PLANNING BOARD

August 7, 2014

Project Name:	Bayside Anchor	Project ID:	2014-079
Address:	81 East Oxford Street	CBL:	22-I-001
Applicant:	Portland Housing Authority		
Planner:	Richard Knowland

**L1.0**

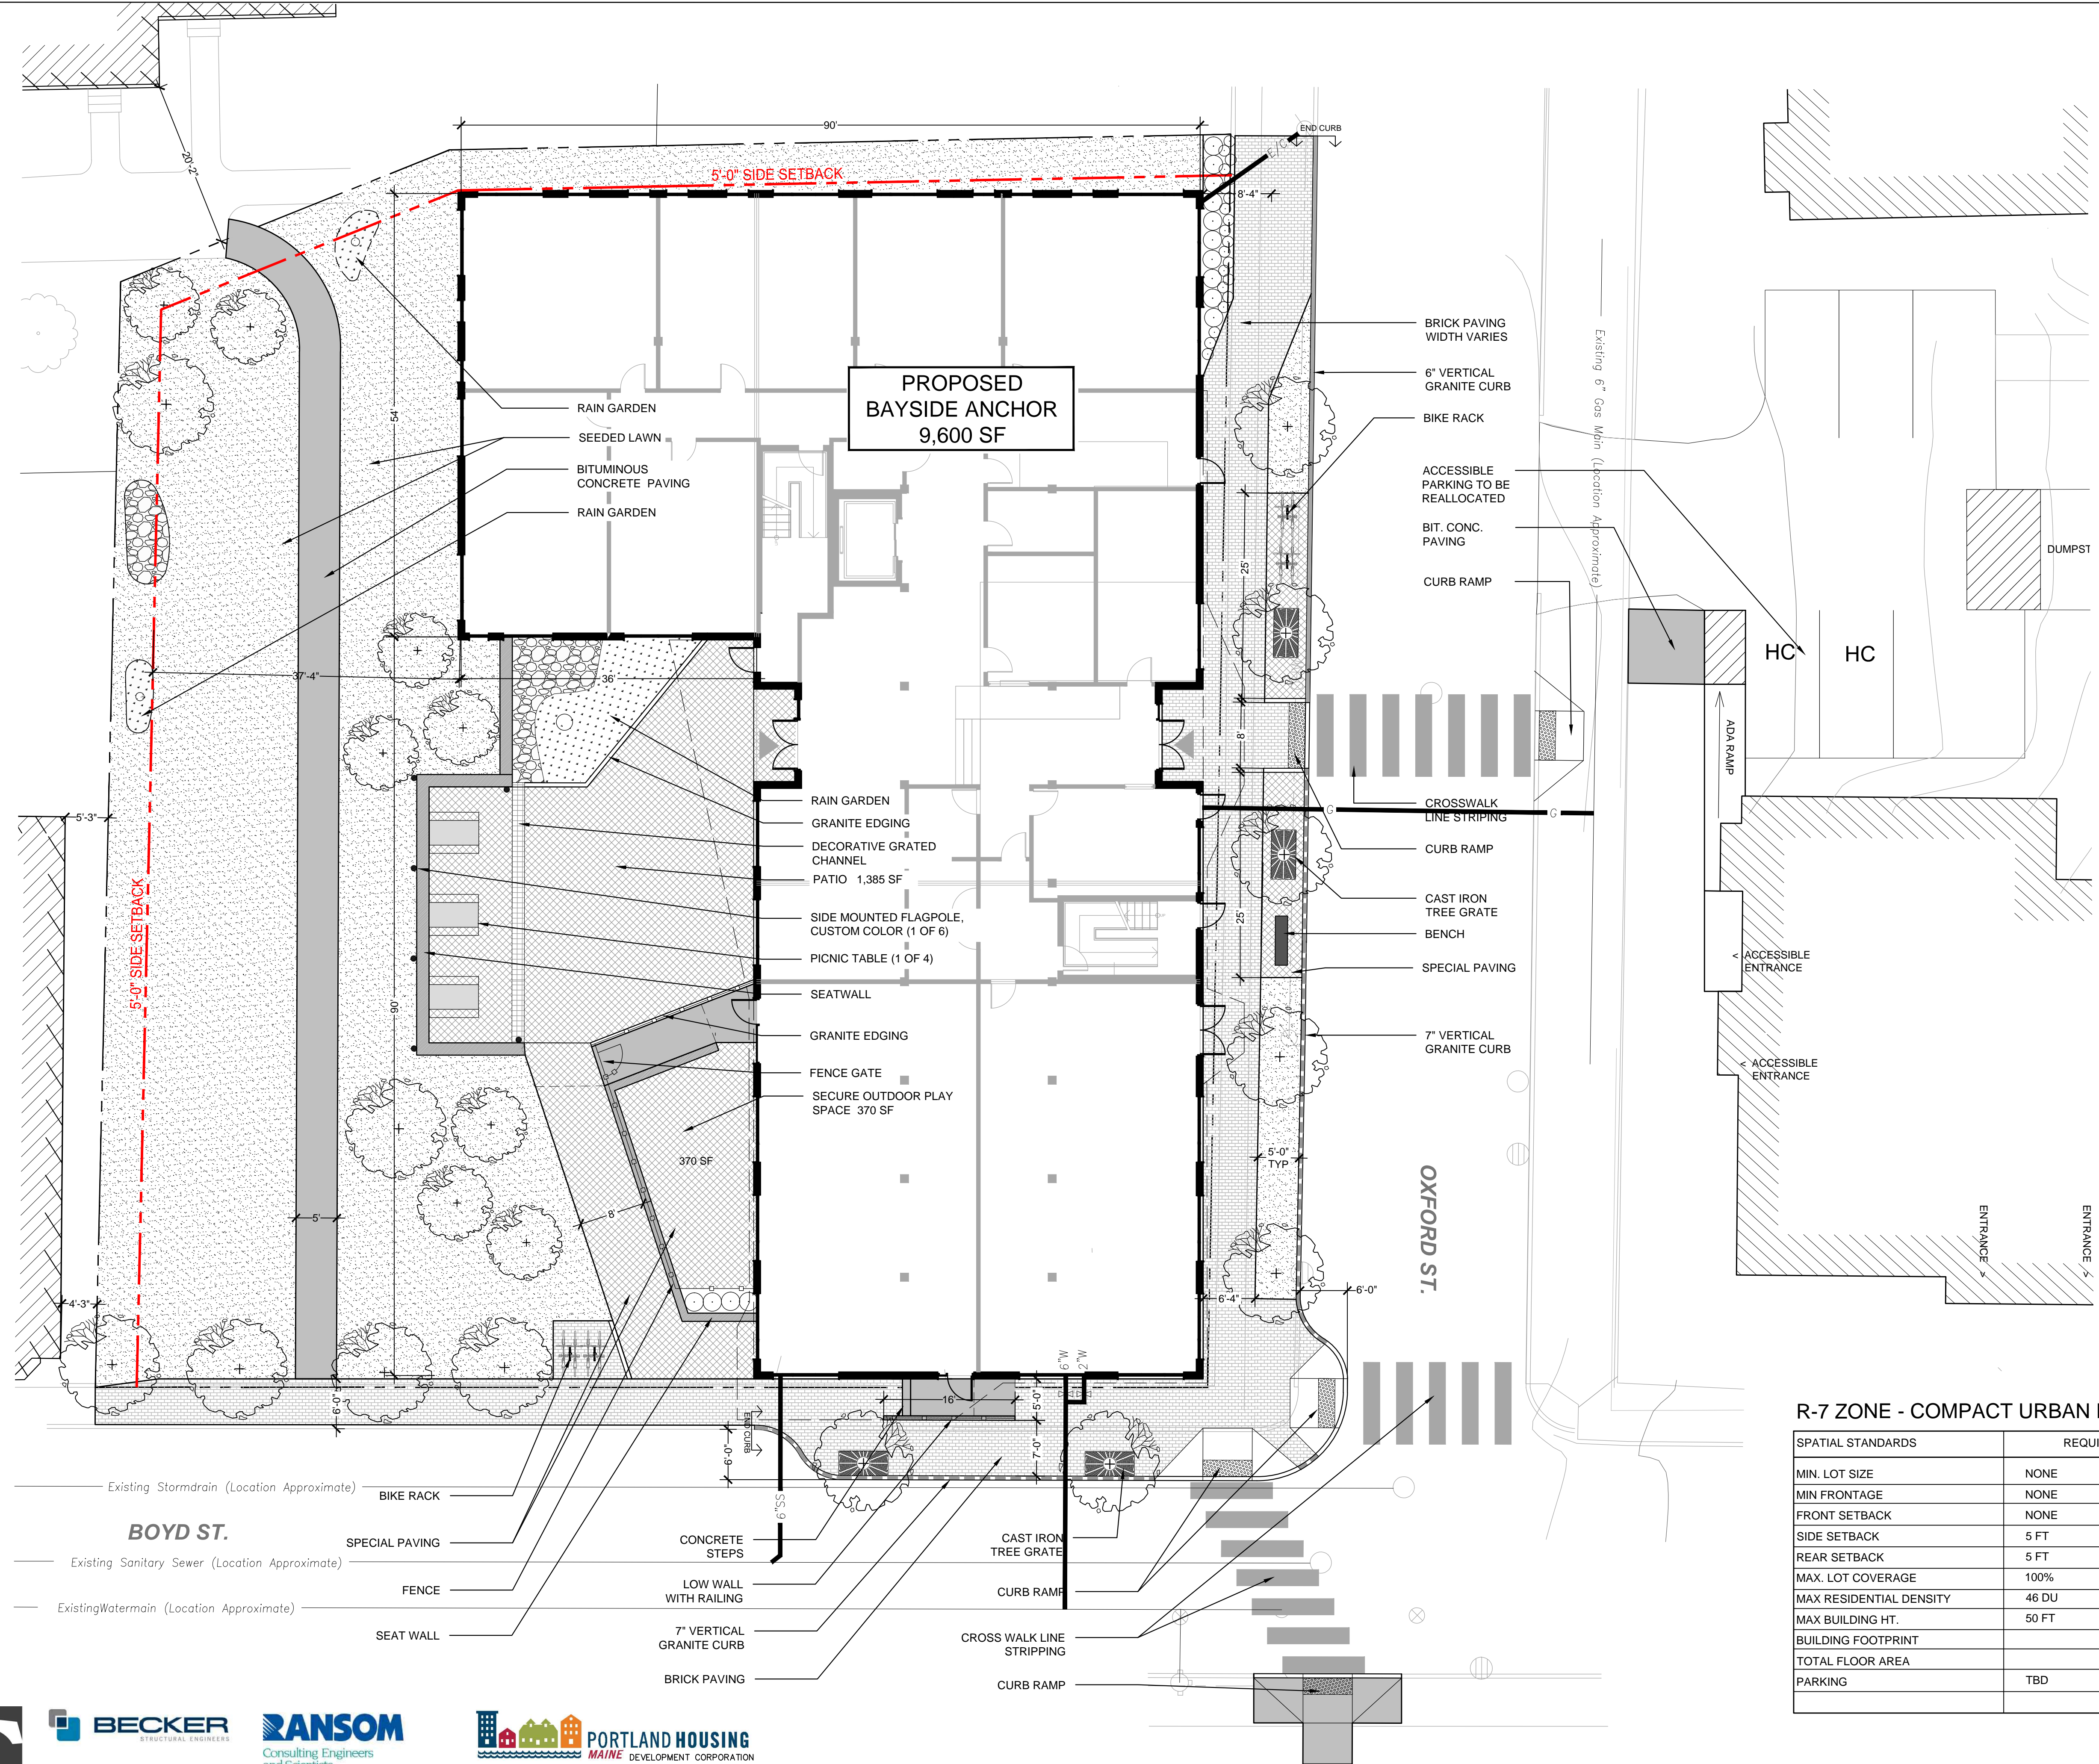
8. That the site plan shall be revised eliminating the concrete pavers shown within the Boyd Street esplanade and replaced with brick or an acceptable material unless an agreement is made between the PHA and the City for the concrete pavers.

Drawing: **SITE GRADING AND STORMWATER PLAN**
Scale: 1"=10'
Date: Monday, May 12, 2014
Revised: **L2.0**

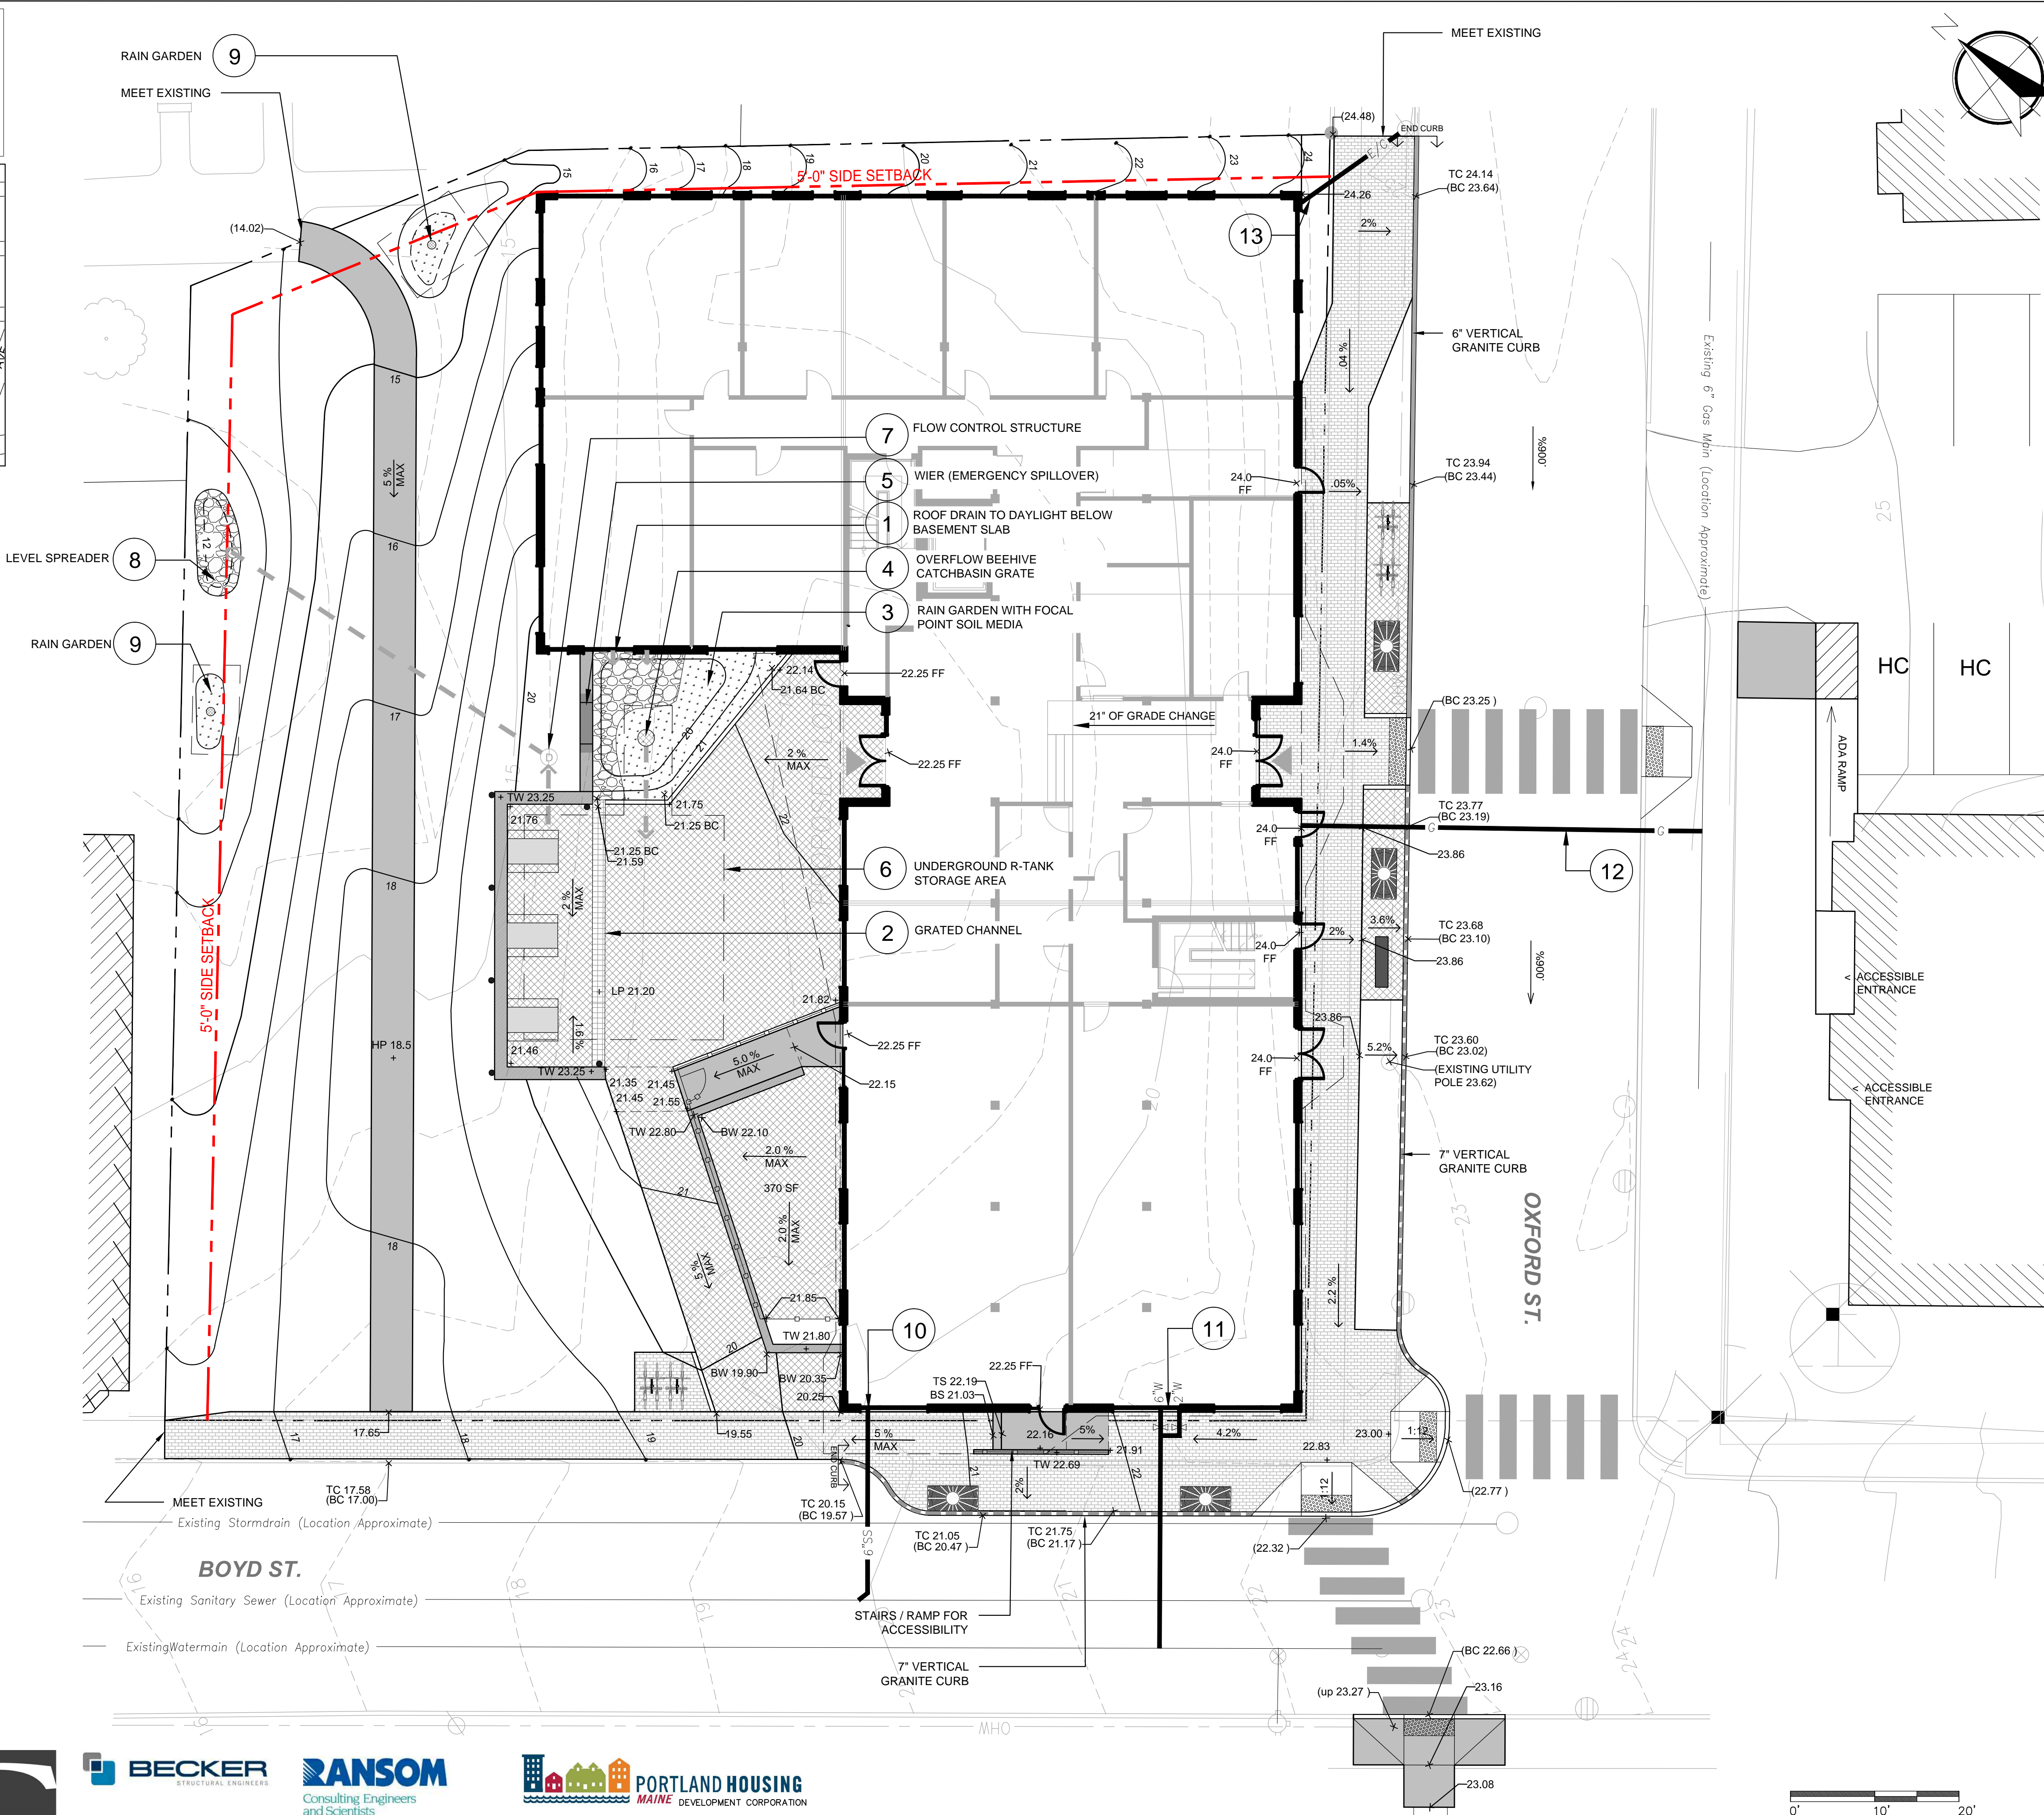
4. That a revised site plan shall be submitted for review and approval by David Senus (Development Review Engineer) reflecting the following revisions. The typical trench detail (sheet C-2) shall be modified to reflect the City's standard (Fig II-12 of the Technical Manual) for all pipe work within the right-of-way. The existing storm drain pipe shall be demolished to the right-of-way line and remaining portion of the existing storm drain pipe in the street shall be abandoned following the procedures outlined in Section 2.6.11 of the City's Technical Manual.
